CITY OF ALBUQUERQUE

June 15, 2020

**RE: 4600 Edith Blvd NE – SWMD Admin. Office and Vehicle Maintenance
Drainage Report (Engineer's Stamp 5/15/2020)
Hydrology File: G15D202**

JRMA Project No. 4907-B
W&C - 14-100-132-01
C-305

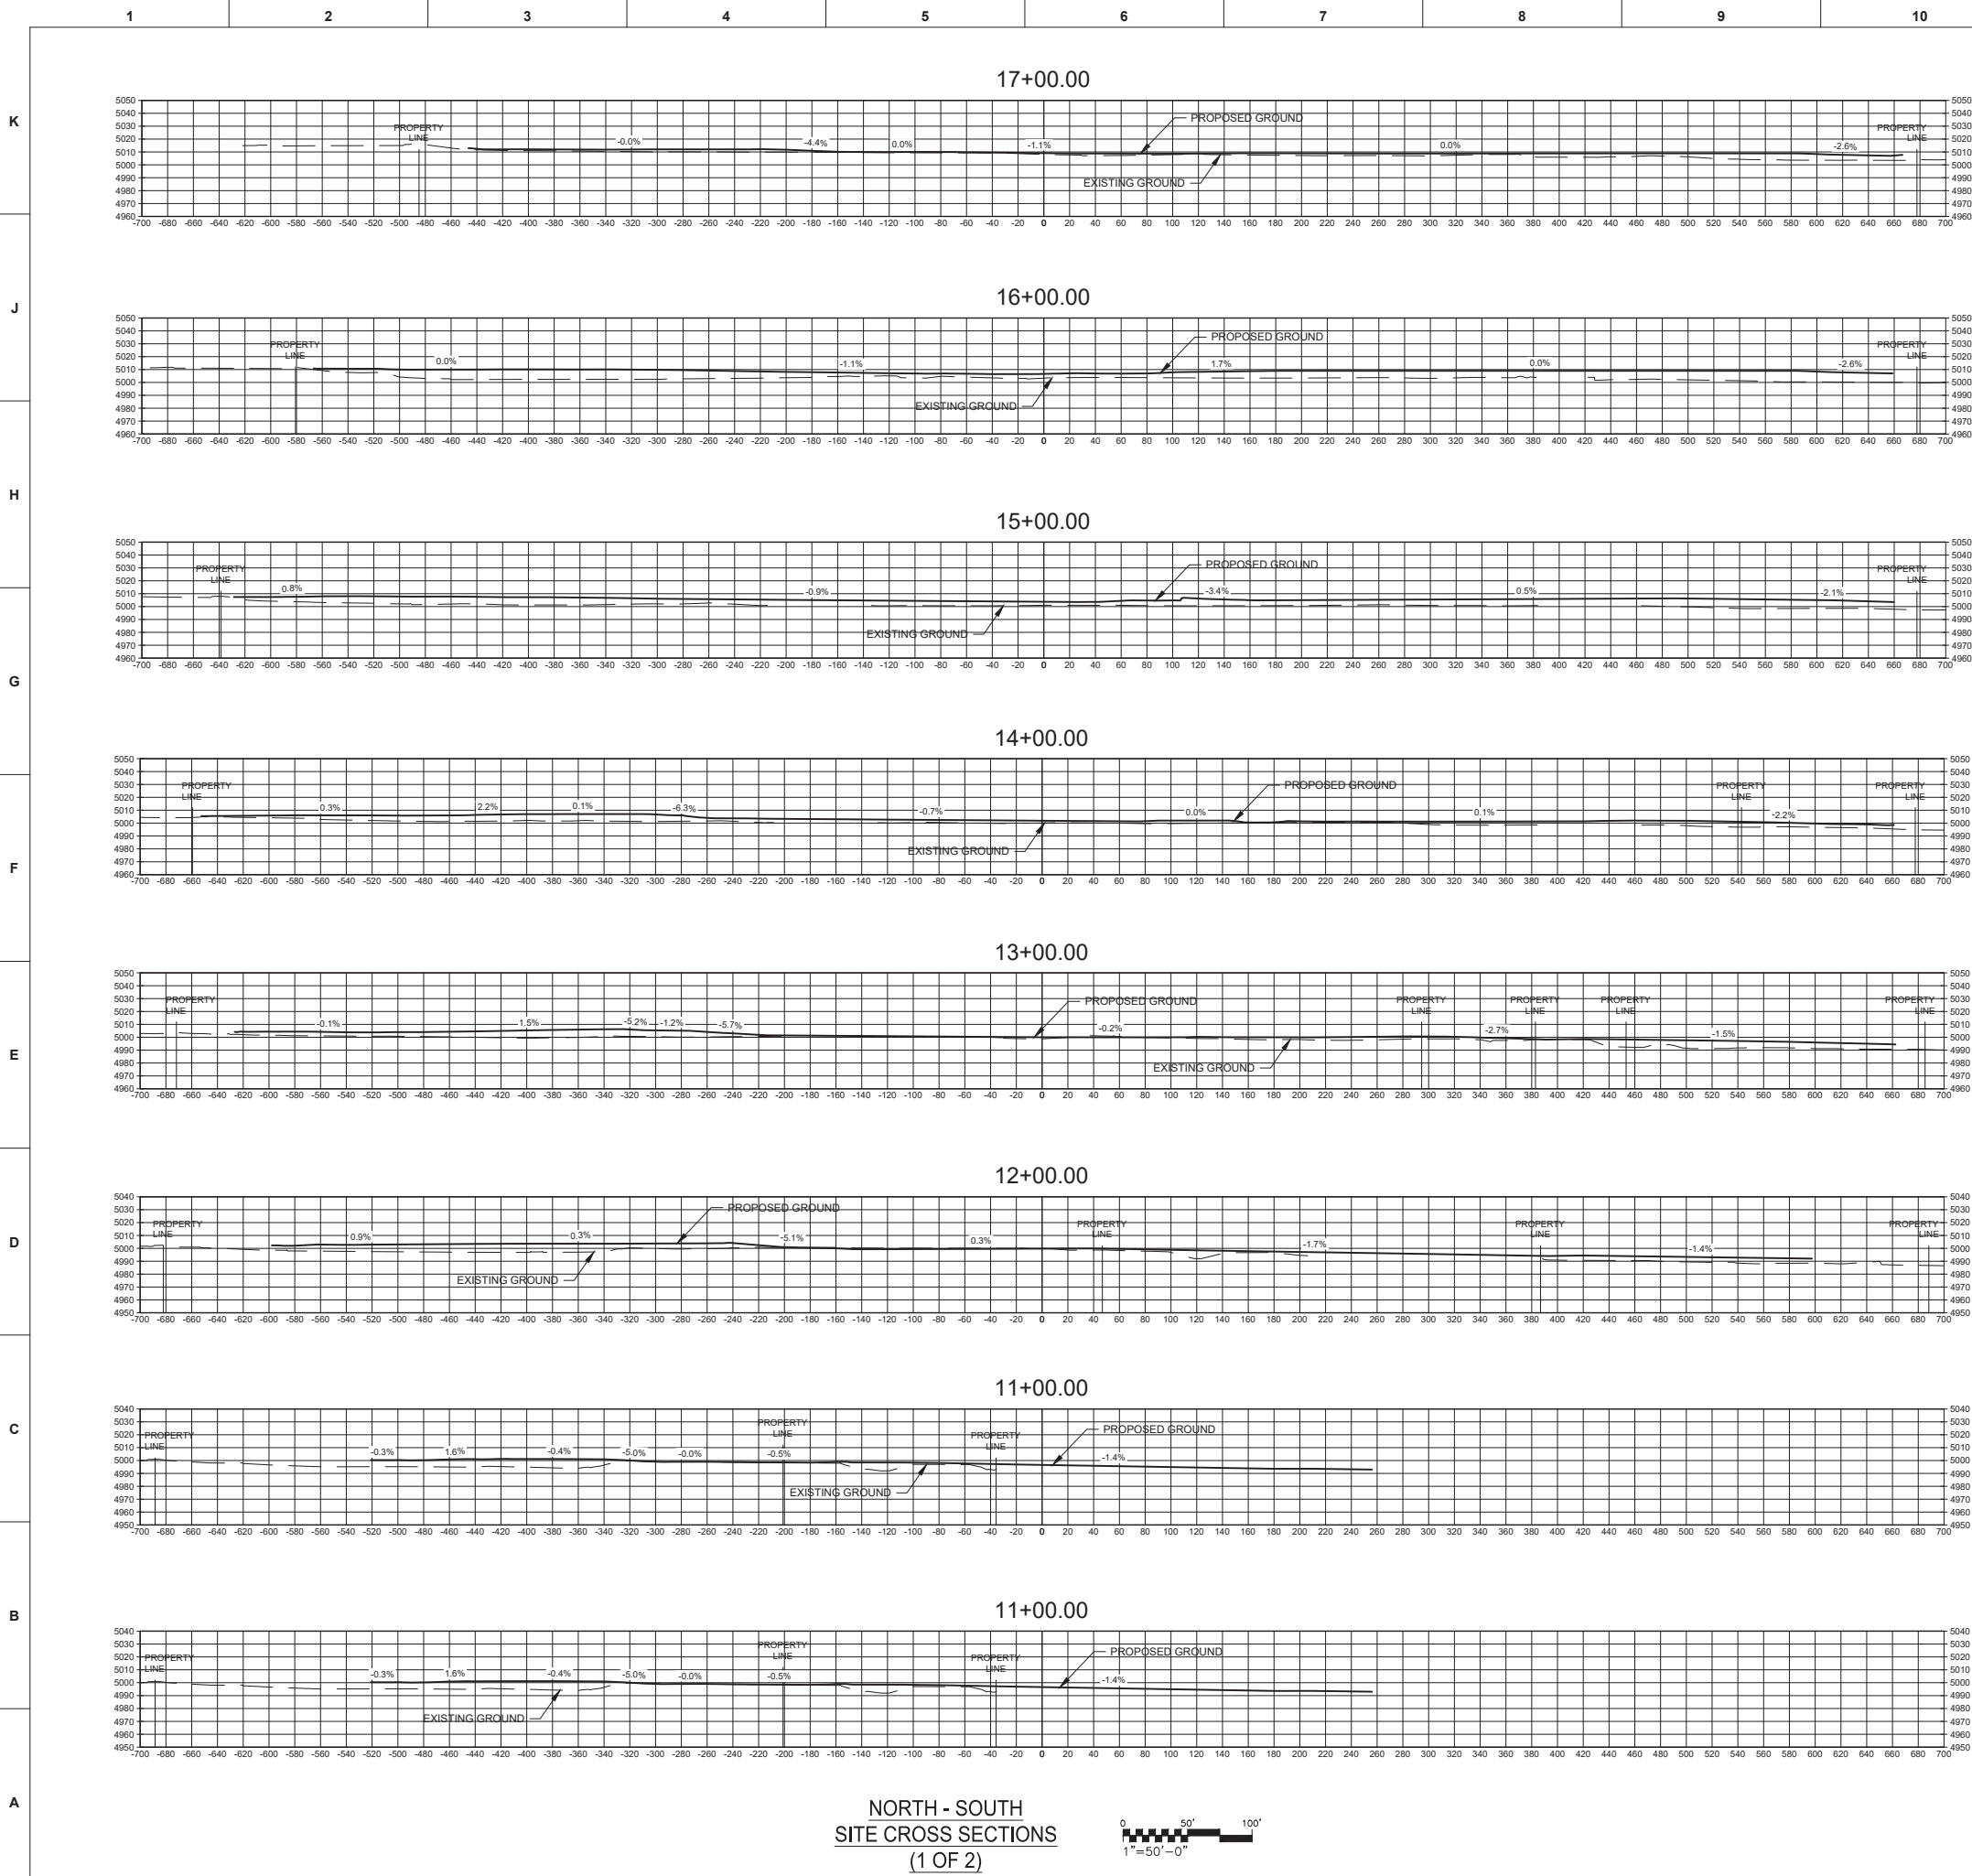
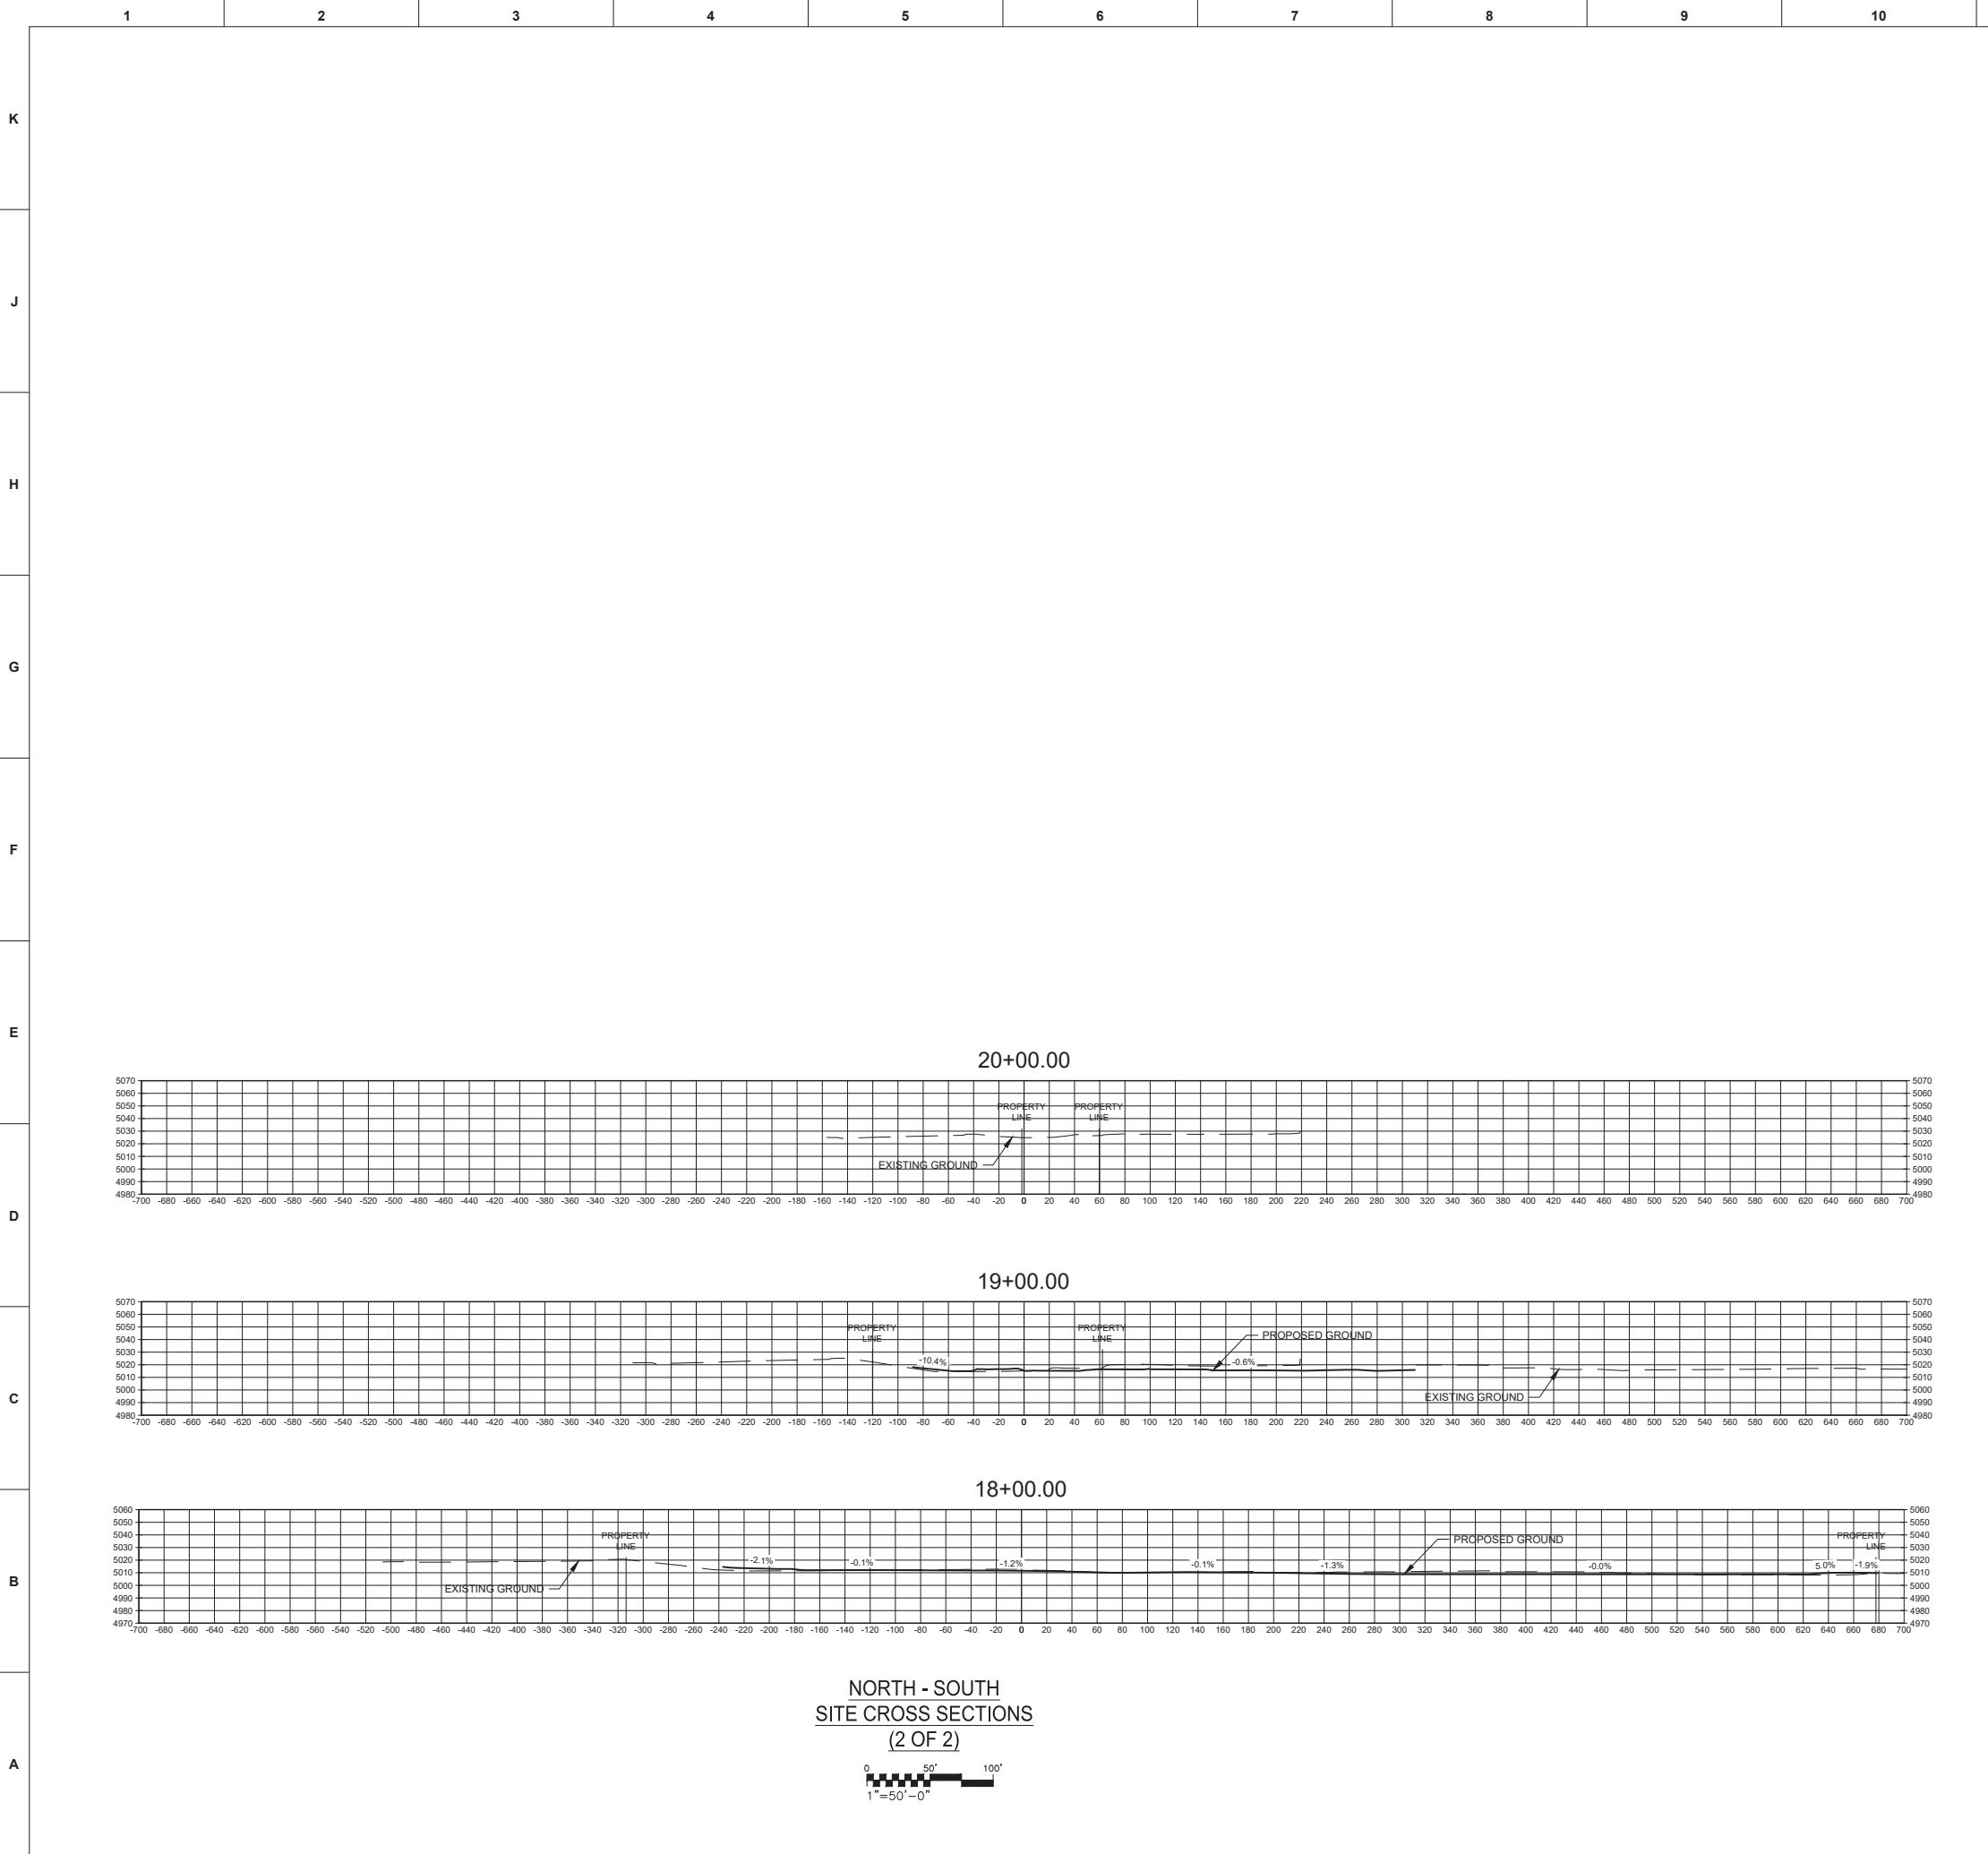
5. Typical sections should be shown in the north-south direction also. Please indicate what direction the cross section is looking. Each section should show the property line, both the existing and proposed grades, slopes and walls with dimensions, both horizontal and vertical, as necessary to demonstrate compliance with DPM 22.5.B
